September 7, 2005

SUBJECT: Permit Modification Request for TIP No. R-2809B and C, Wake County, NC DOT Division 5, Federal Aid No. STP-98(1), State Project No. 8.1402501, USACE Action ID 199601836, and DWQ Project No. 010550, \$475 Debit Work Order WBS Element 34503.1.1

On April 4, 2002 and February 4, 2002 respectively, the USACE 404 Individual Permit and the NCDWQ 401 Water Quality Certification and Neuse River Riparian Certification were issued for project R-2809. On October 27, 2004 and October 13, 2004 respectively, modifications to the USACE 404 Individual Permit and the NCDWQ 401 Water Quality Certification and Neuse River Riparian Certification were last issued. The North Carolina Department of Transportation (NCDOT) proposes to modify the construction plans for the abovementioned project. The purpose of this letter is to request a modification to the Department of the Army Individual Permit, the 401 Water Quality Certification as well as the Buffer Certification from the NC Division of Water Quality. The revised sheets of the original permit drawings, revised design plan sheets and a revised EEP confirmation letter are attached.

N.C. DEPT. OF TRANSPORTATION
 DIVISION OF HIGHWAYS
 WAKE COUNTY
 PROJECT: 34503.L1 (R-2809B)
 NC 98 WAKE FOREST BYPASS
 SHEET 17 OF 26 REV 8/05

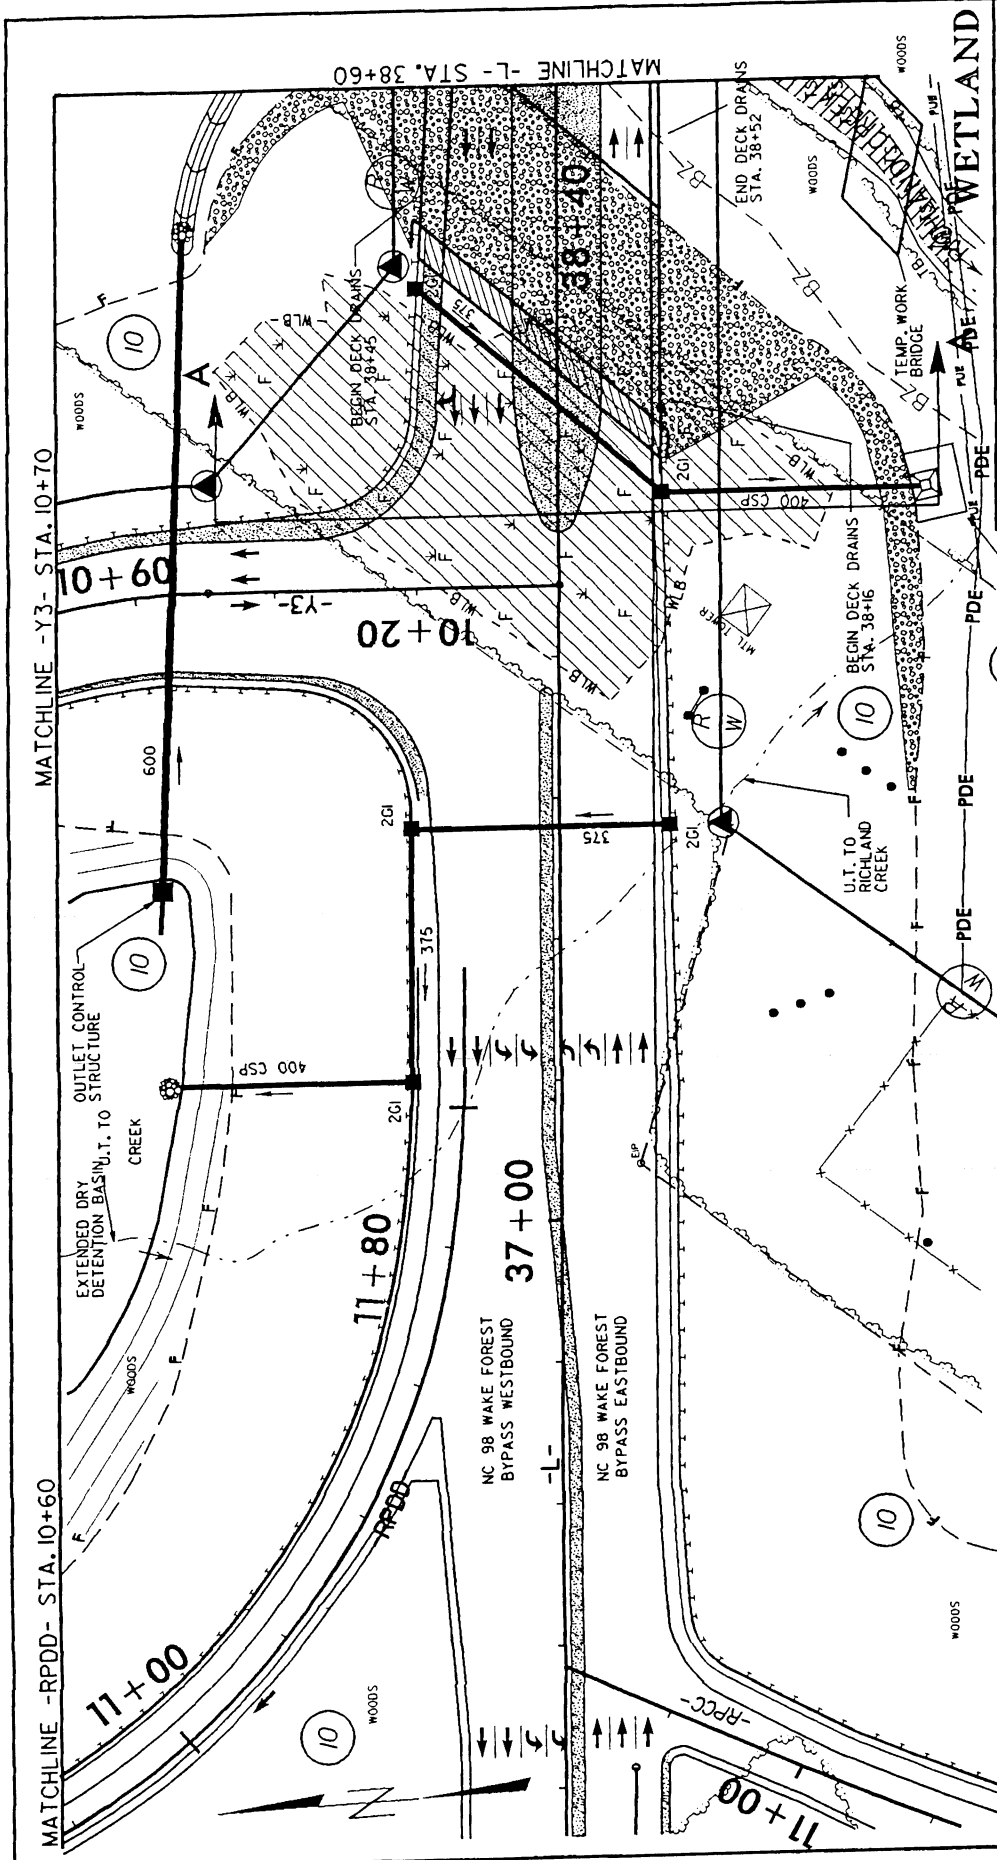
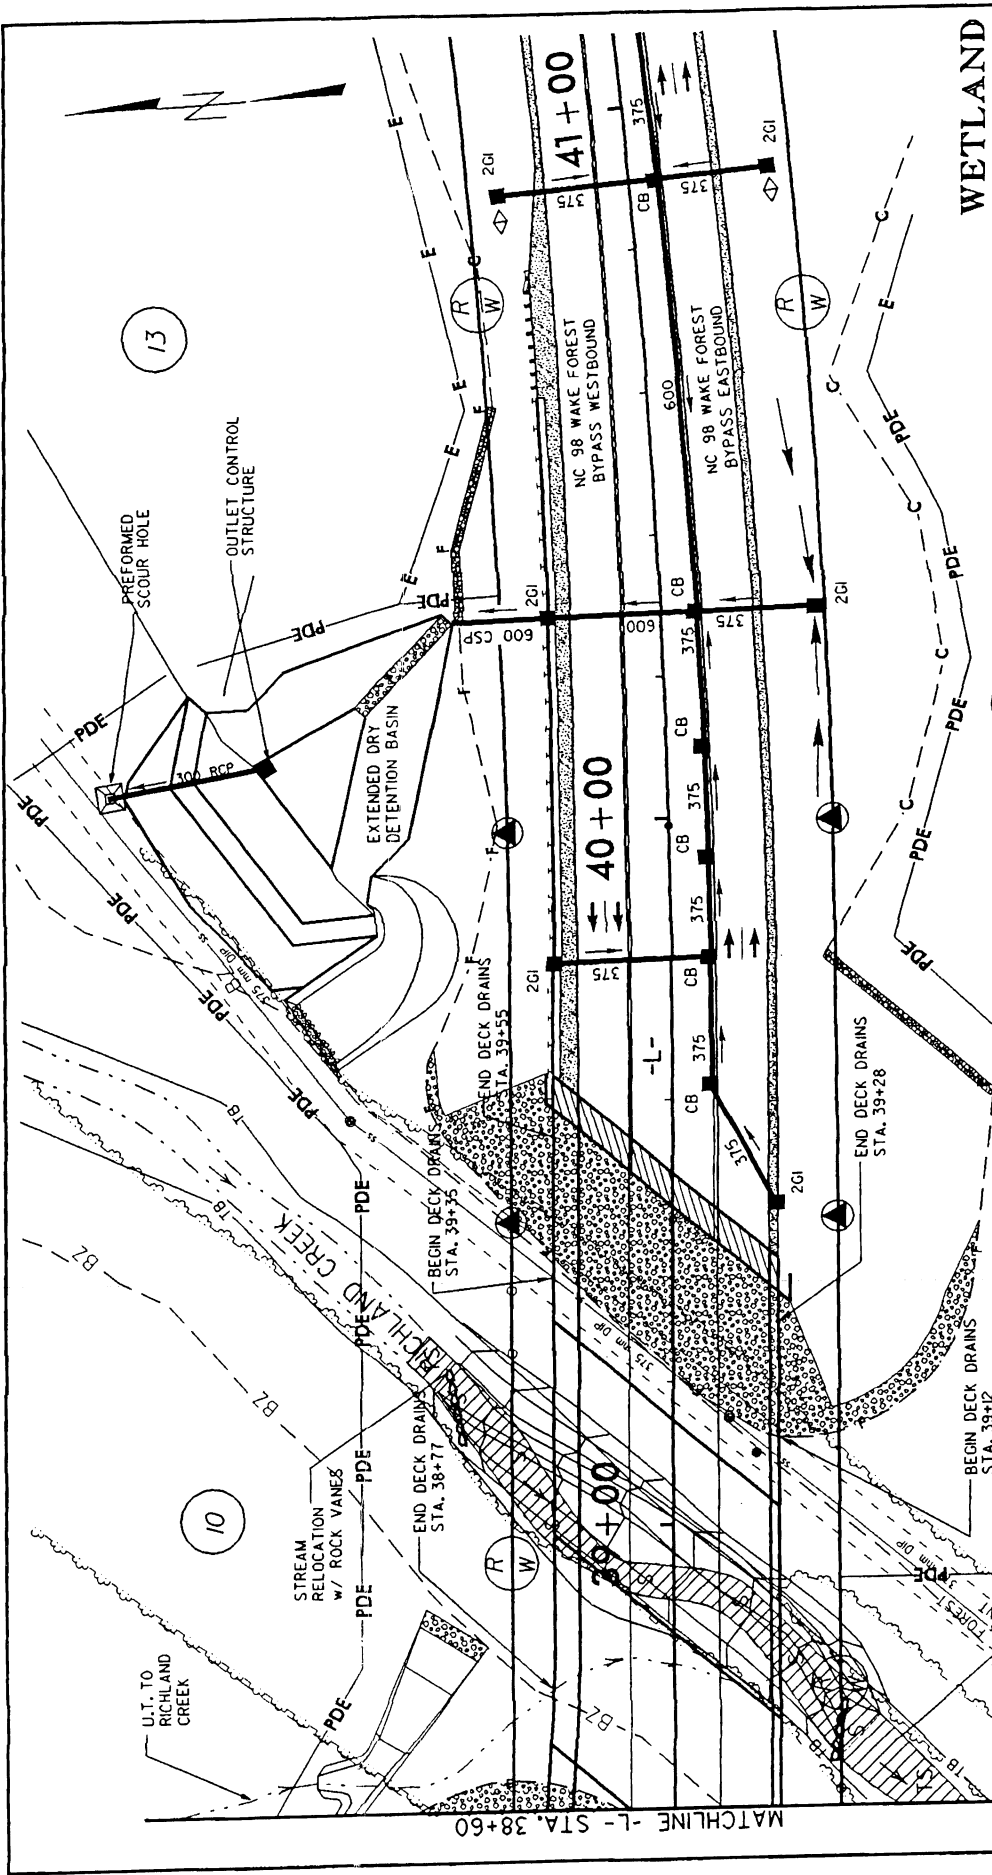
R-2809B Site 4, Sheets 17 and 18 of 26

Plans for the prior approved relocation of Richland Creek using natural channel design have been revised so that a smaller portion of the channel will be impacted. The only portion of Richland Creek that will be relocated using natural channel design will be the portion adjacent to the bridge bent number 2. Revised plan view and cross sections have

been included with the permit drawings showing the revised stream relocation.

**Impact change: Decrease of 82 feet of Permanent Stream Impacts
Decrease of 82 feet of Natural Stream Design**

SHEET 7 OF 12 REVISED 5/05

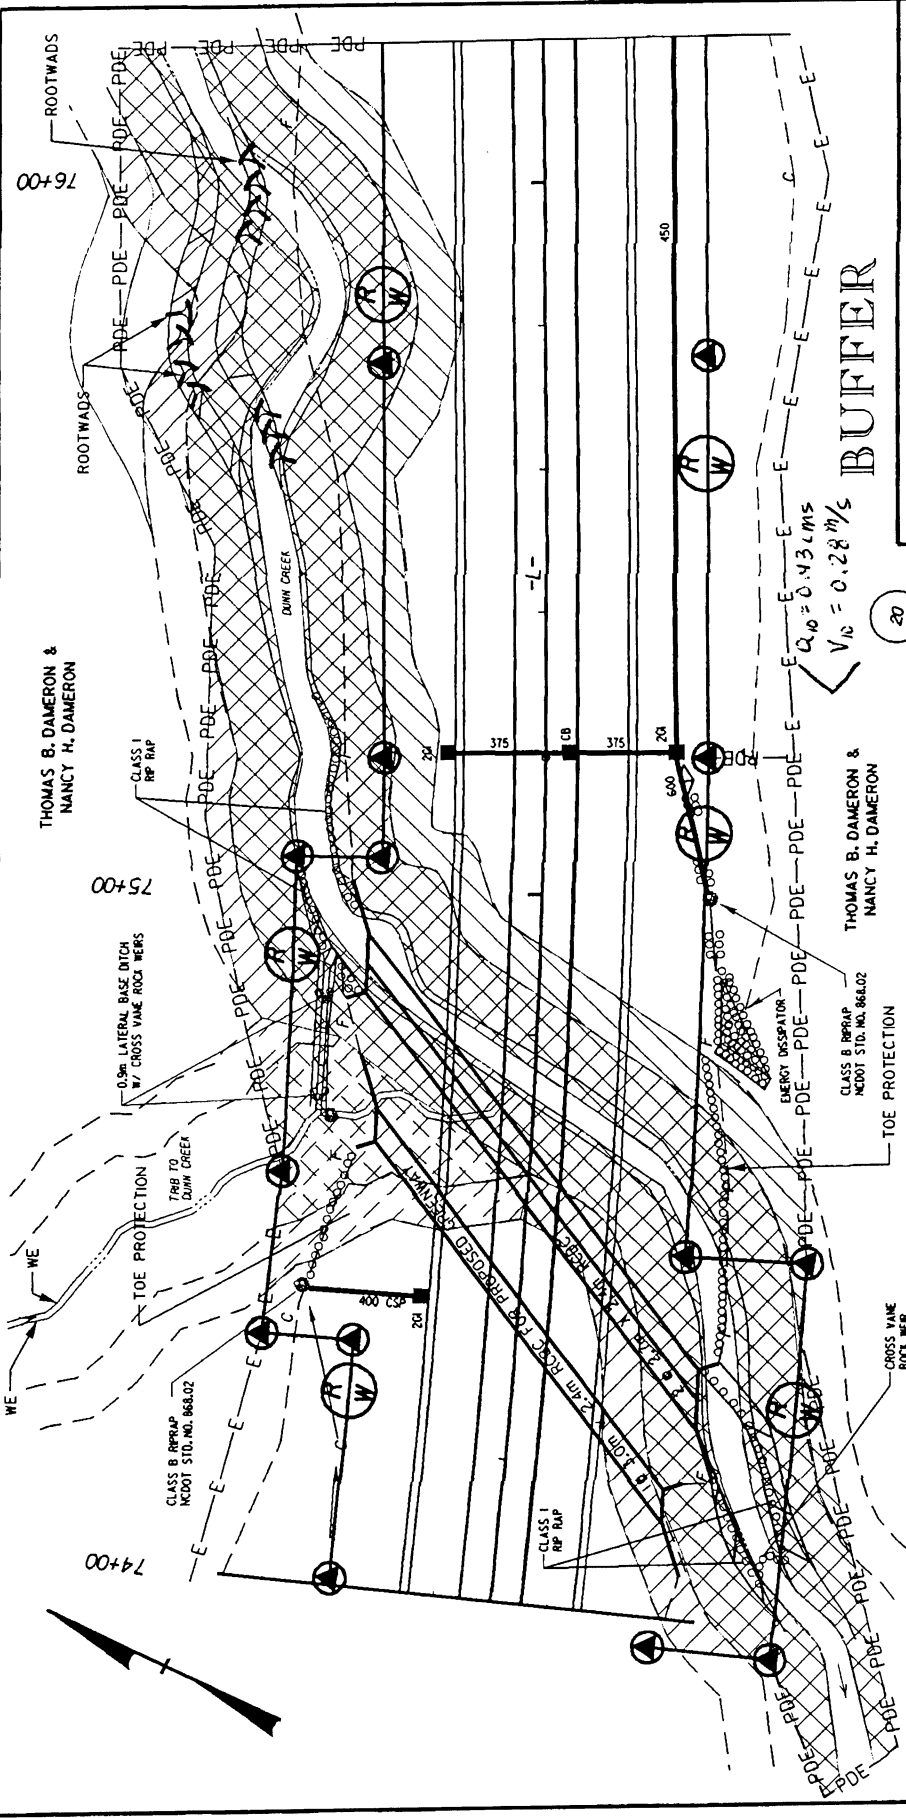
R-2809C Site 4, Sheet 7 of 12

The bank at the culvert inlet and outlet was re-graded so the fill from the roadway could tie into the natural elevation of the stream bank. Rip rap was also installed on 63 feet of the bank for bank stability where the bank was re-graded

Impact change: Increase of 63 feet of Permanent Stream Impacts

Increase of 30 feet of Temporary Stream Impacts

Decrease of 46 feet of channel relocation using natural channel design

SHEET 5 OF 12 REVISED 5 / 05

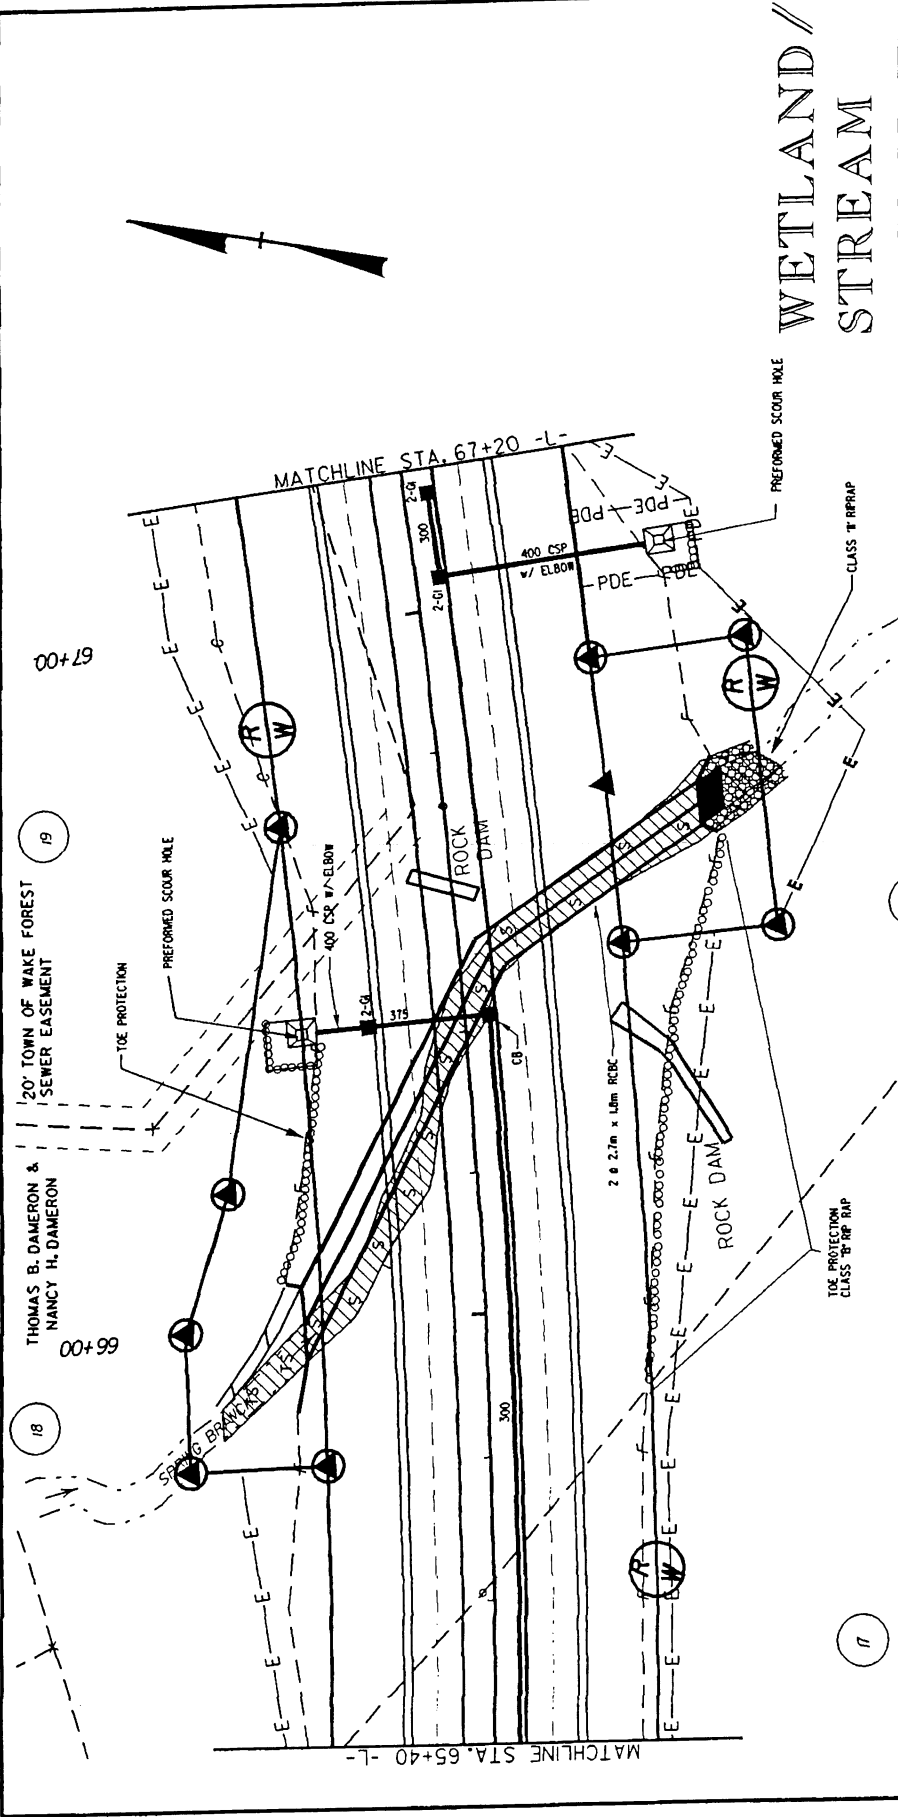
R-2809C Site 2, Sheet 5 of 12

The impacts at this site have increased due to stream bank grading at culvert inlet. No mitigation is proposed because impacts are temporary

Impact change: Increase of 53 feet of Temporary Stream Impacts

SHEET 6 OF 12 REVISED 5/05

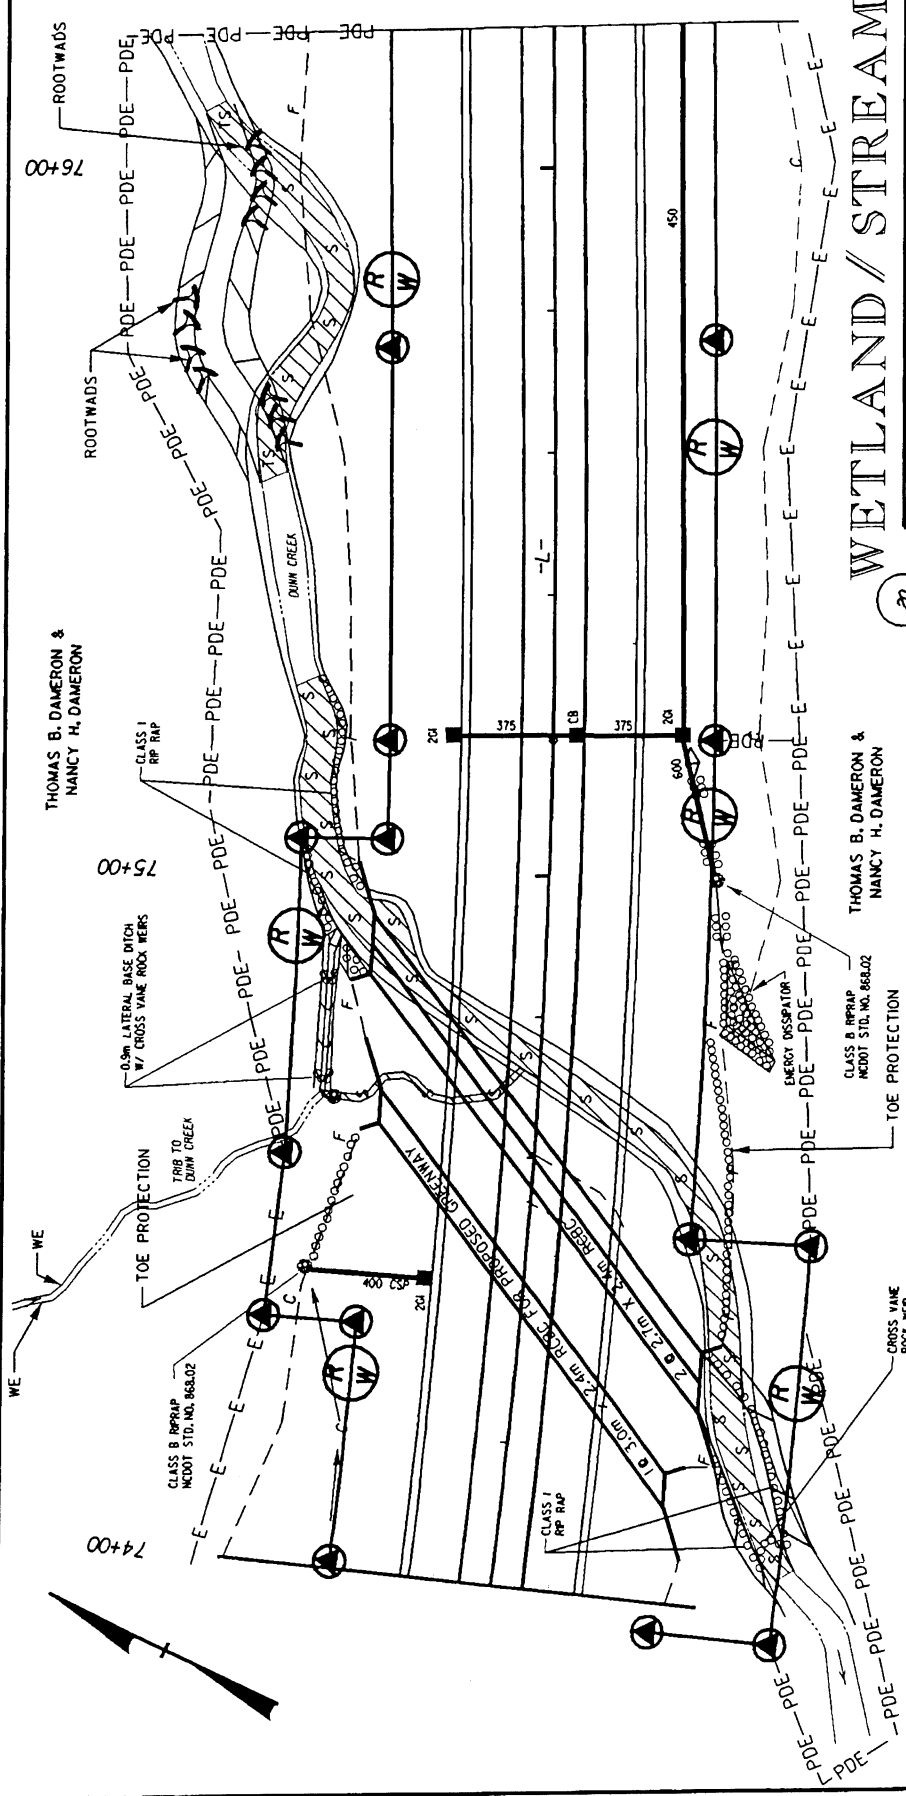
R-2809C Site 3B, Sheet 6 of 12

The bank at the culvert inlet and outlet was re-graded so the fill from the roadway could tie into the natural elevation of the stream bank. Rip rap was also installed on 95 feet of the bank for bank stability where the bank was re-graded

Impact change: Increase of 105 feet of Permanent Stream Impacts

Increase of 53 feet of Temporary Stream Impacts

Decrease of 14 feet of channel relocation using natural channel design

PLAN VIEW SITE 5

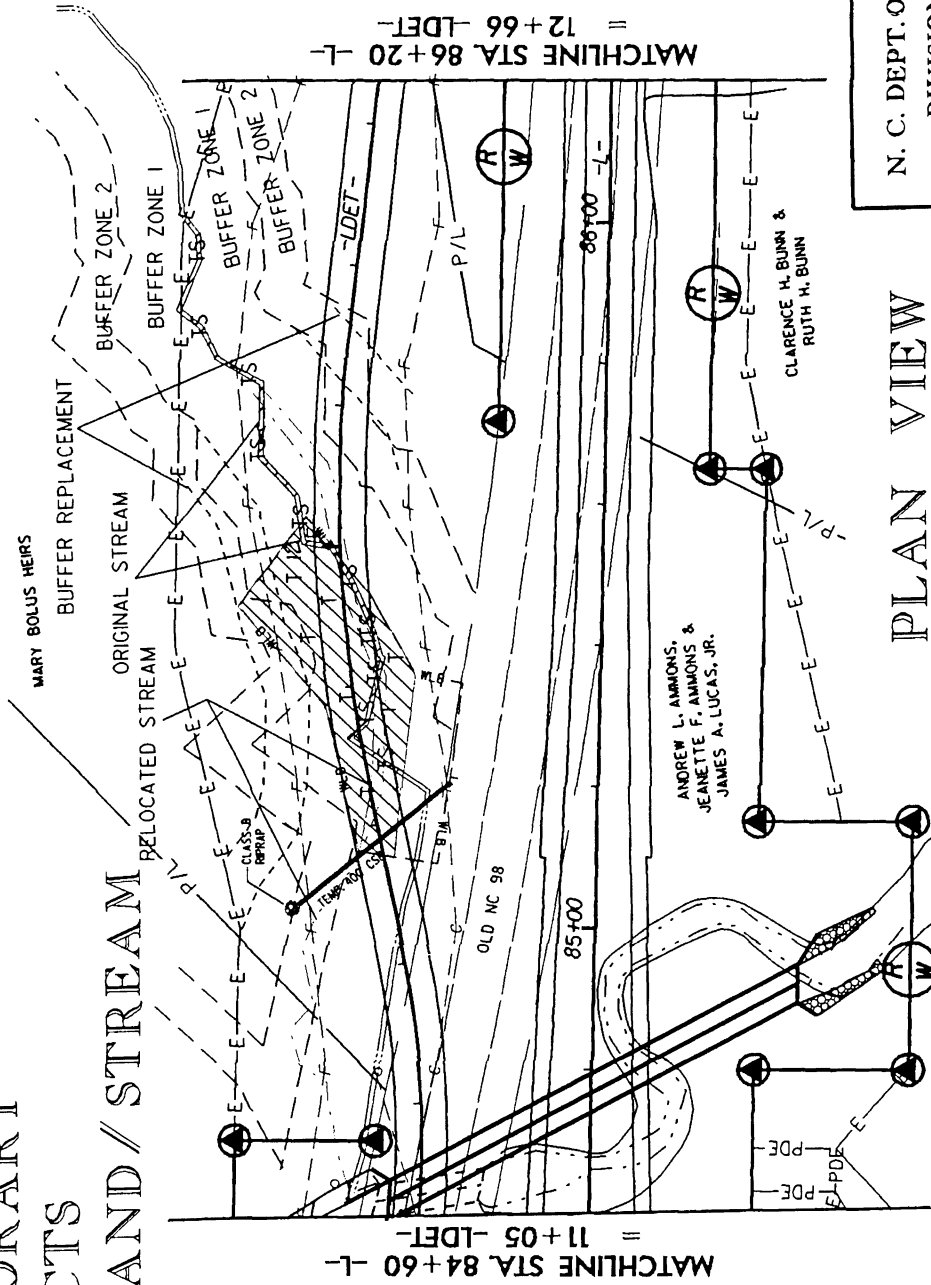
R-2809C Site 5, Sheet 8 and 8B of 12

Construction access to build the temporary lateral base ditch required use of the entire construction easement. A step pool was also constructed to tie in the Unnamed Tributary at the culvert inlet at Station 84+80-L-. When the original permit application was submitted, temporary stream impacts were not calculated on the Impact Summary Sheets. If the impacts were reported at that time they would have been estimated to be 197 feet. Total temporary impacts now total 322 feet.

Impact change: Increase of 125 feet of Temporary Stream Impacts
